**SOIL/SITE EVALUATION
 for ON-SITE WASTEWATER SYSTEM**

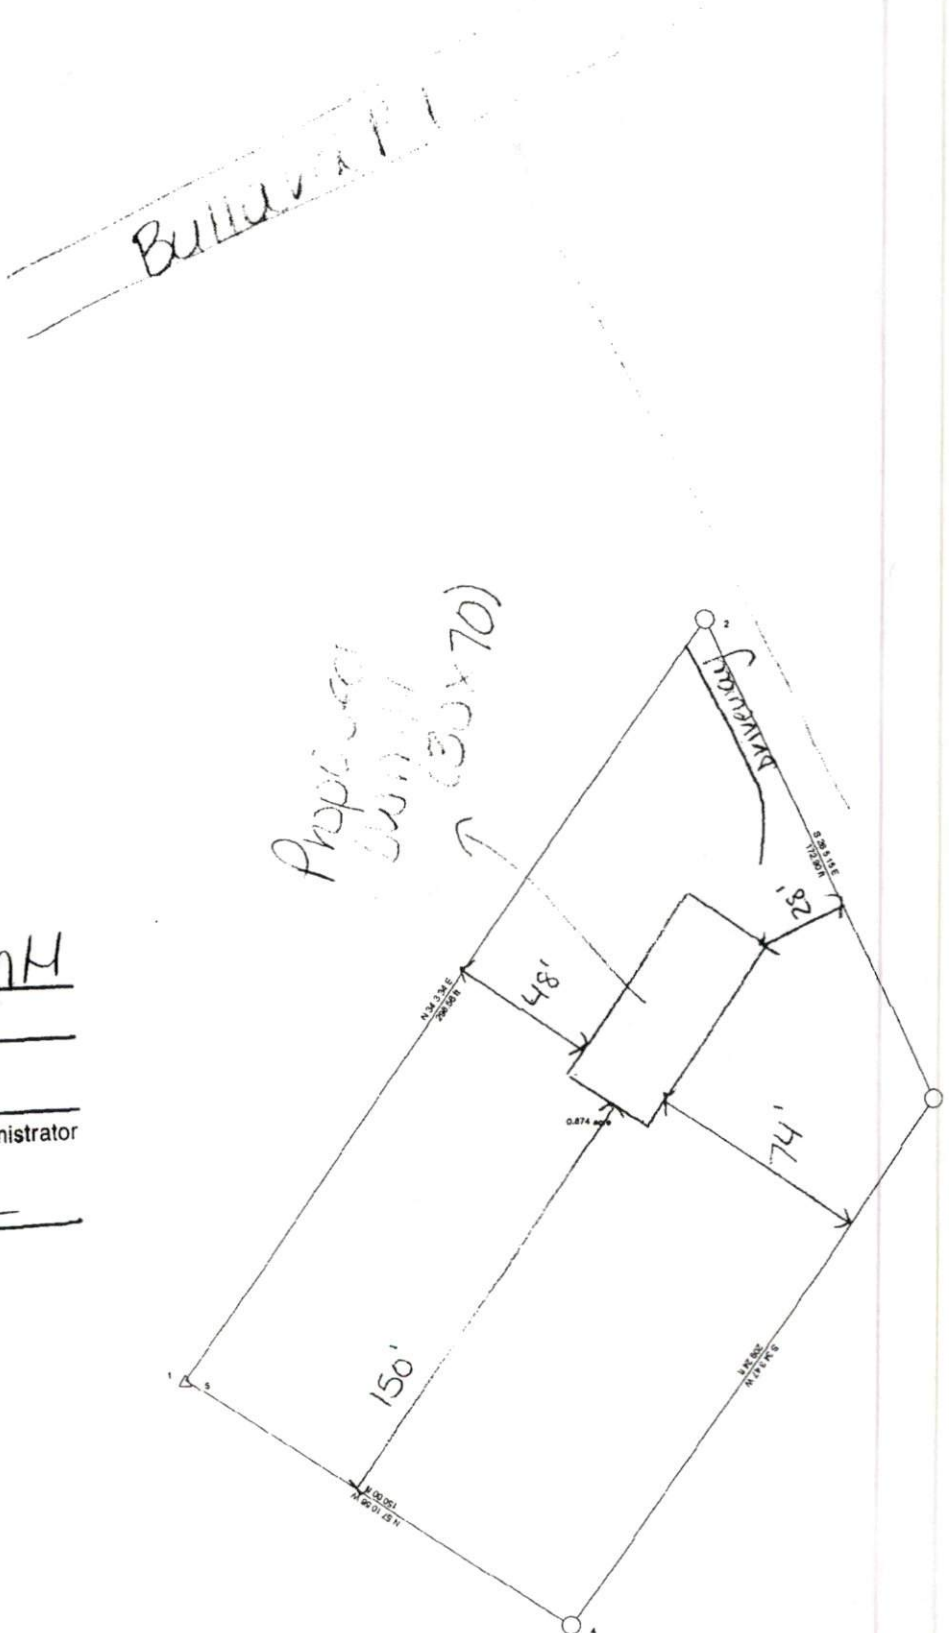
Change to 20% reduction to save space

*Mechanics
 close from 3
 BR to 4 BR
 1 Room is w. his
 office
 4 occupancy*

*Proposed
 DWMH
 (30x70)*
